City of Albuquerque Stormwater Construction Site Inspection Report

General Information					
ESC File No.	A10E002A		Project Name:	Seville Subdivision	
NPDES Id. No.	Not identified		Location:	Brookline Dr. NW	
5/28/2021	Owner		Contractor		
Operator	John R. DeBassige				
Contact name & title	John R. DeBassige				
e-mail	jrdebassige@yahoo.com				
Contact Phone #	505-710-3775				
COA Inspector	Thomas Evans		Start/End Time:	2:45 PM-2:55 PM	
Construction Phase:	earthwork/grading				
Type of Inspection:	Regular	Storm Event	Past Storm Event >0.25"	311/Complaint	Follow Up
Weather at time of inspection?	clear		Temperature:	~ 88	
Estimated date of last storm 0.25" or greater	5/3/2021

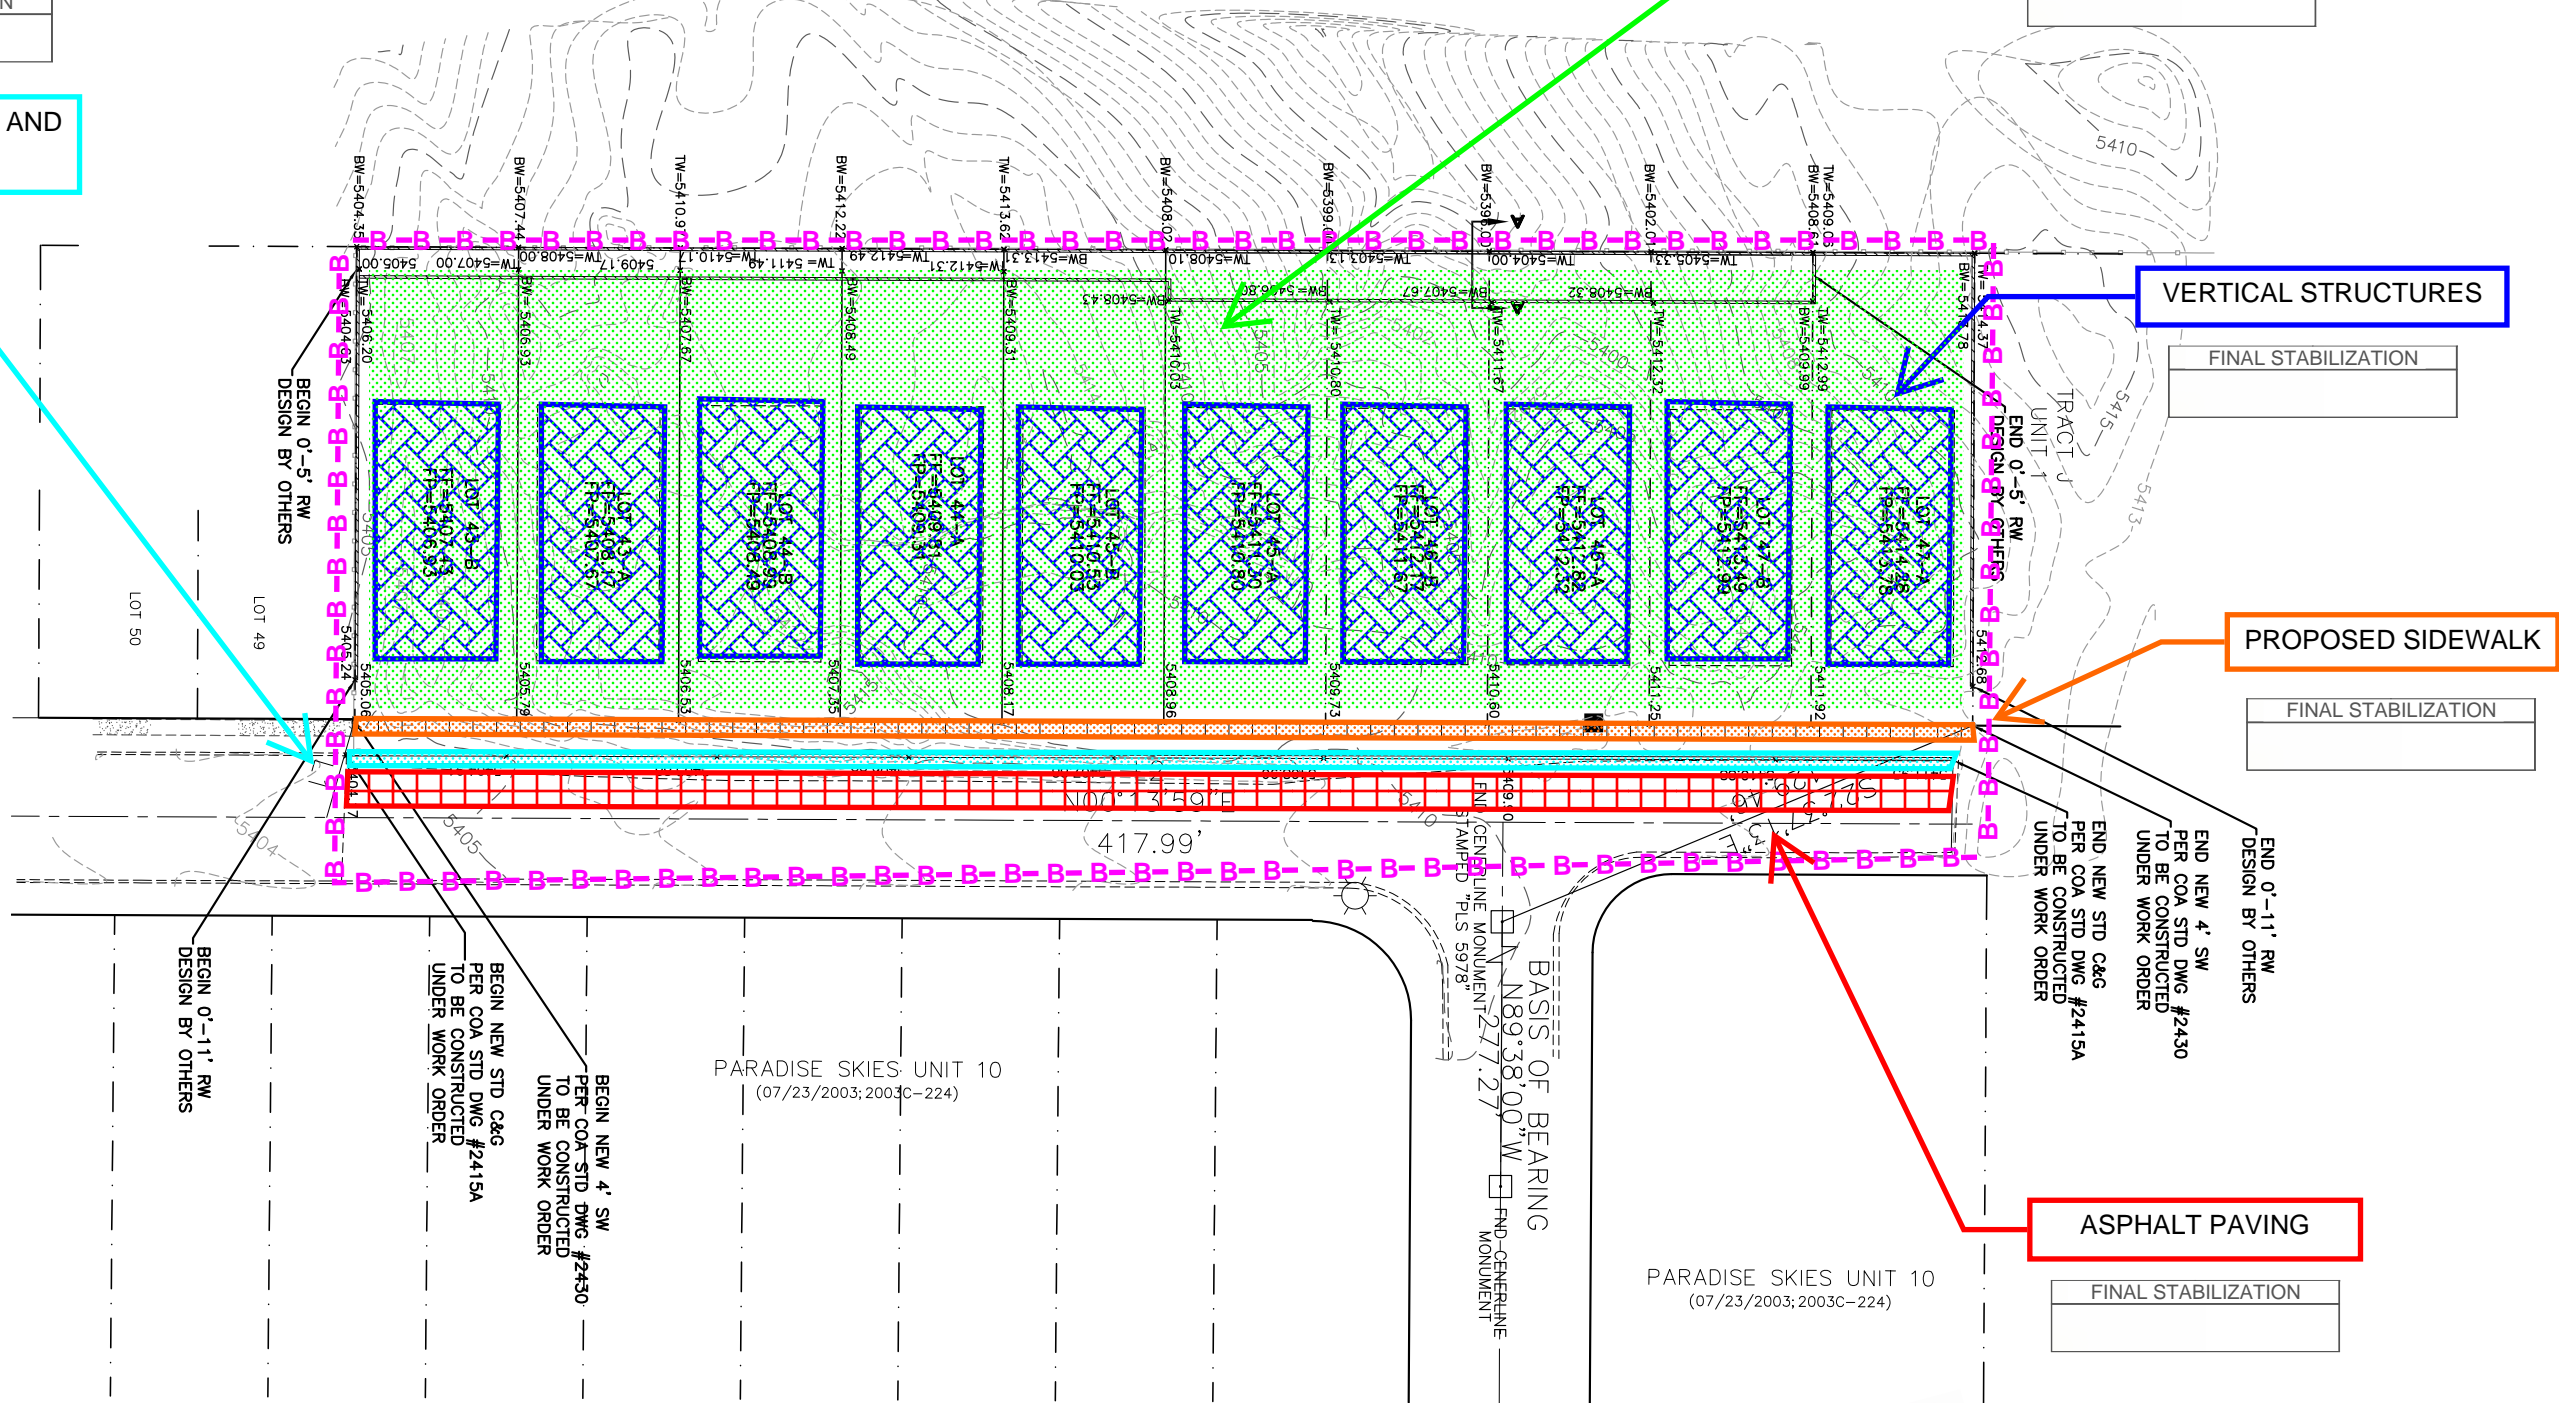
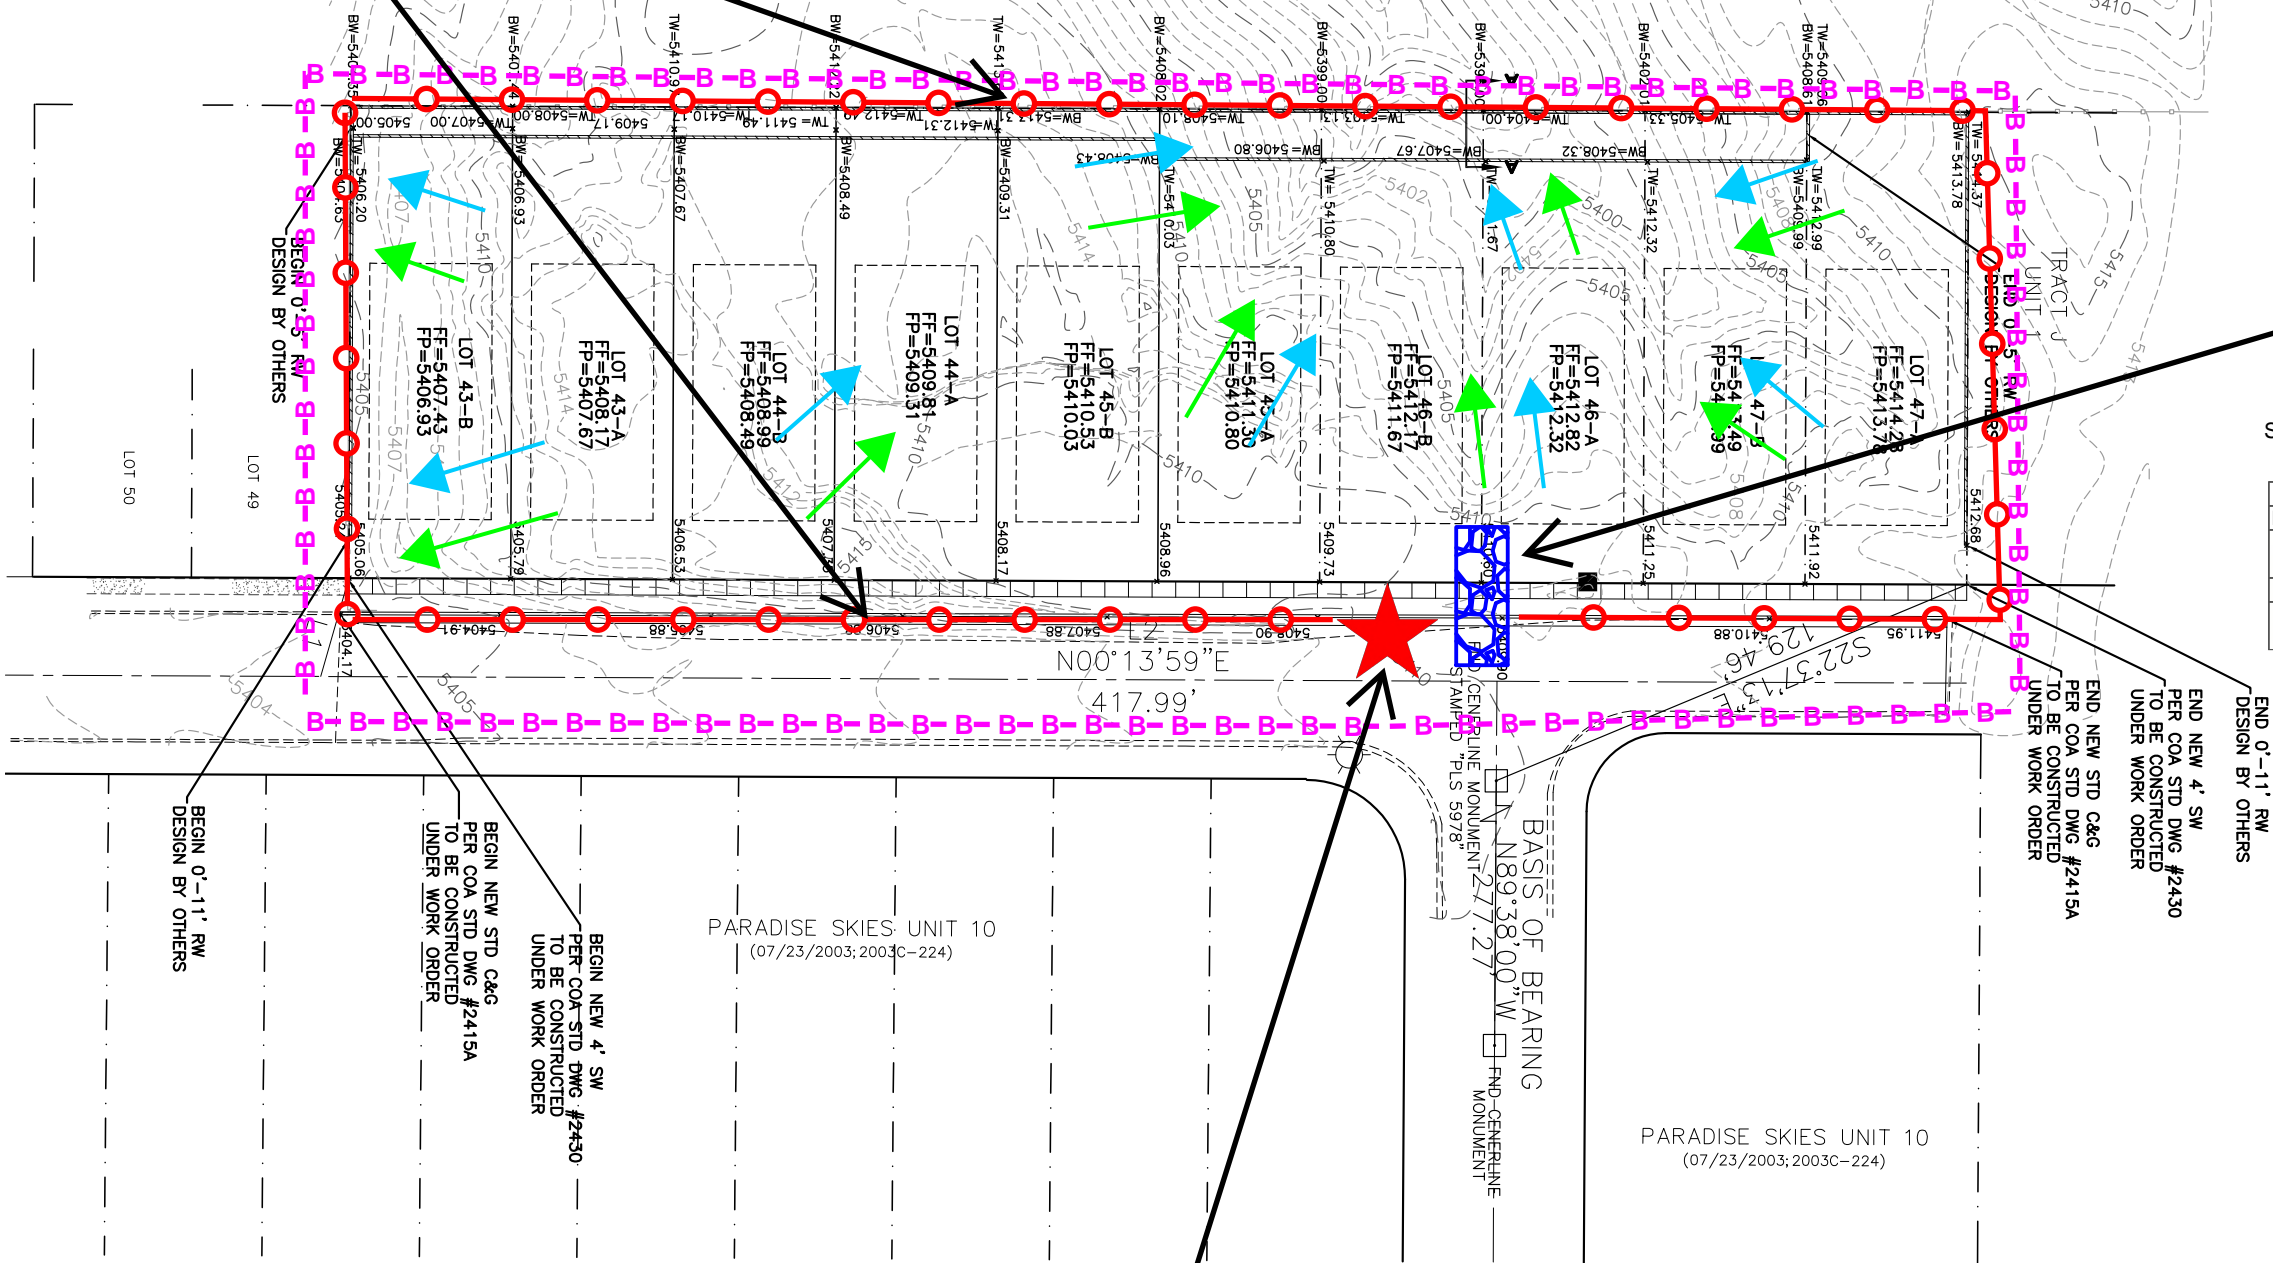
Item Number	Deficiency/ Corrective Action				
1	Sediment in the street. Sweep and remove sediment from the street daily.				
2	Domestic waste on site. Remove domestic and construction waste daily and place into an approved waste container.				
3	No posting of NOI permit coverage. Post signage of NOI permit coverage in a location clearly visible to the public.				
4	No erosion and sediment controls along West boundary of the site. Install silt fence or another BMP along the West boundary.				
5
